Planning Application Reference Number: ACP-324165-26

Applicant: Maughanaclea Ltd / Enerco

Description of Development: 10 year planning permission for Maughanaclea Wind Farm consisting of 14 no. wind turbines, a 110kV substation and 110kV underground cabling connection and associated works

Location: Maughanaclea, County Cork

Figure 13-3 Topographical Landscape Features Map with identification of 'horseshoe'

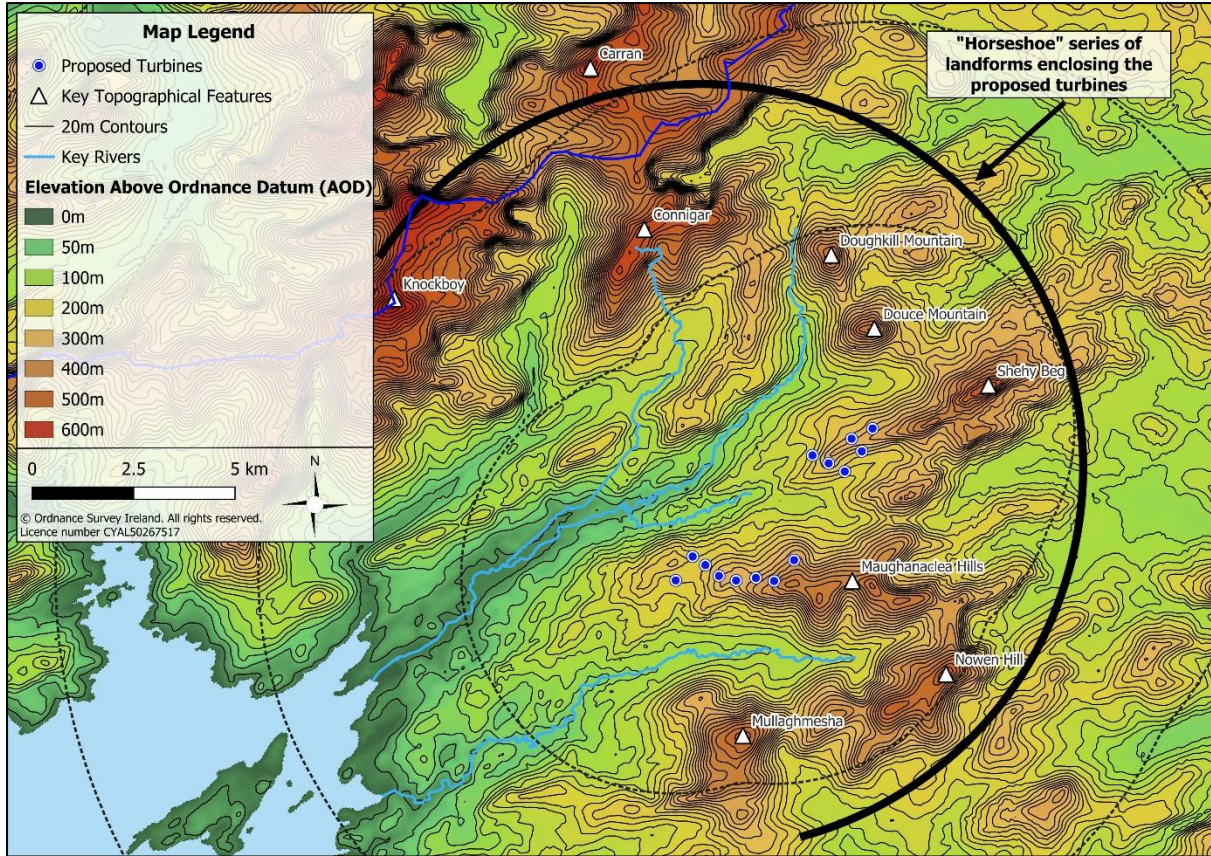
“ZTV and Topographical mapping shows that the proposed turbines are encircled by a horseshoe shaped series of mountainous peaks and large landforms which act as a visual barrier, enclosing the proposed turbines, reducing the visual envelope and restricting visibility of the proposed turbines... excepting only on other mountainous peaks.”

I find this statement remarkable. Looking at a map of the terrain of the area the only 'horseshoe shaped series of mountainous peaks and large landforms' they could be referring to is the ridge running from Sheehy Mountain, across the Cousane Gap and to the south which would indeed restrict visibility, but only from the east. Anyone approaching from the north, south or west would have largely unrestricted views of the turbines as the turbines on the Maughanaclea side would be sited on one of the highest ridgelines in the area and those on the Coomclogh side are sited high on the slopes of Shehy Beg. They would also be highly visible from many points, not least Bantry Bay and the R585 and R 584, scenic routes 28 and 29, as designated in the Cork County Development Plan 2022.

Figure A12-2-3. Final Study Area – 30 dB LA90 Contour for Maughanaclea

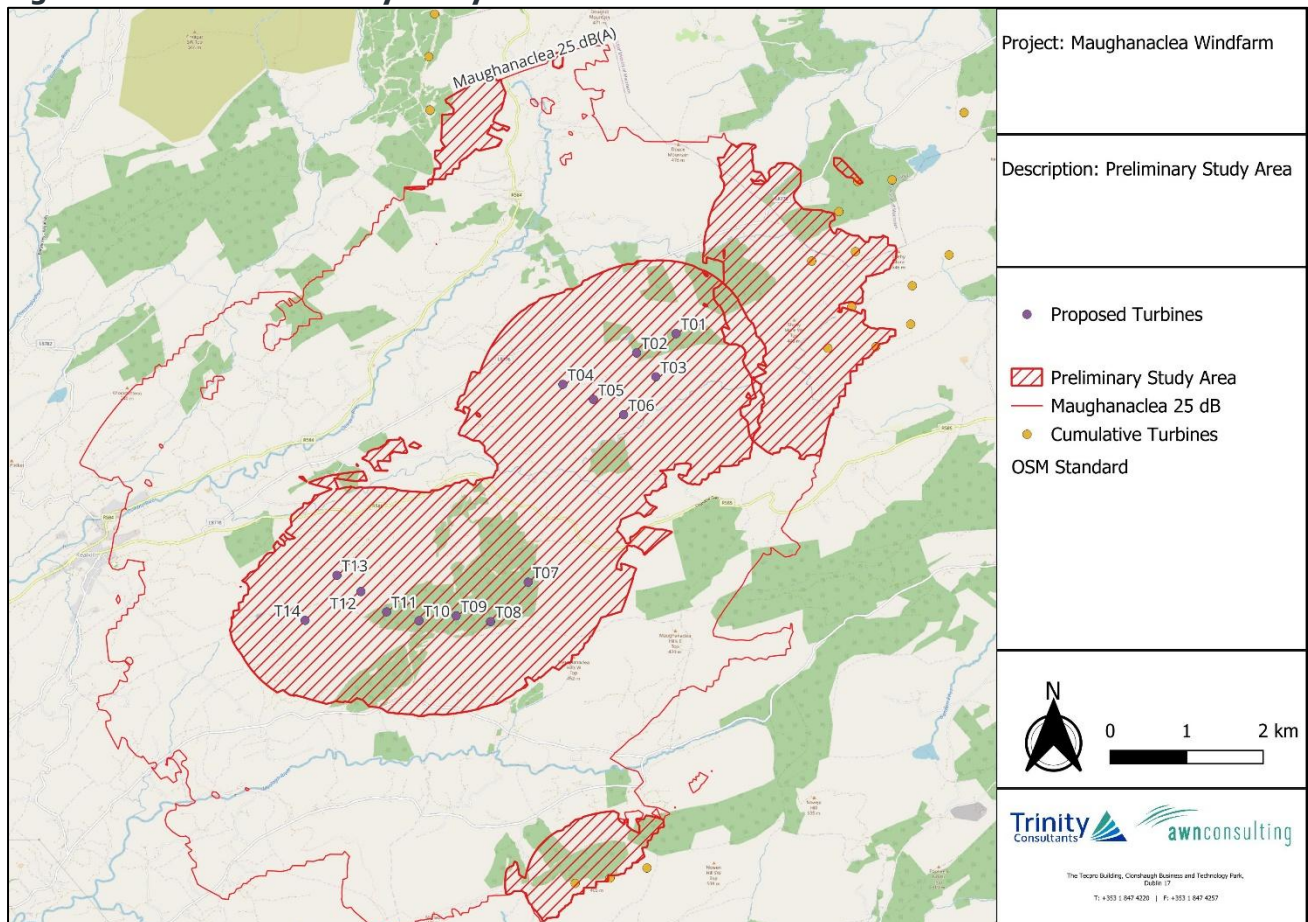
In the EIAR they list the locations of all the noise monitoring locations that were used, only one of which lies within the Mealagh Valley and was located on or in close proximity to two large working farms. This would clearly not reflect a true picture of noise levels at residential properties in the area.

In addition to this there appears to be no consideration given to the unique topography of the area. The east end of the Mealagh Valley is a natural amphitheatre and sound travels long distances, bouncing off the sides of the valley and becoming amplified. Even low level noise can be heard from some distance away. A wind blowing any direction from North West through North to North East would funnel the sound of these turbines directly into that amphitheatre destroying the peace and quiet of this valley that is so valued by its inhabitants.
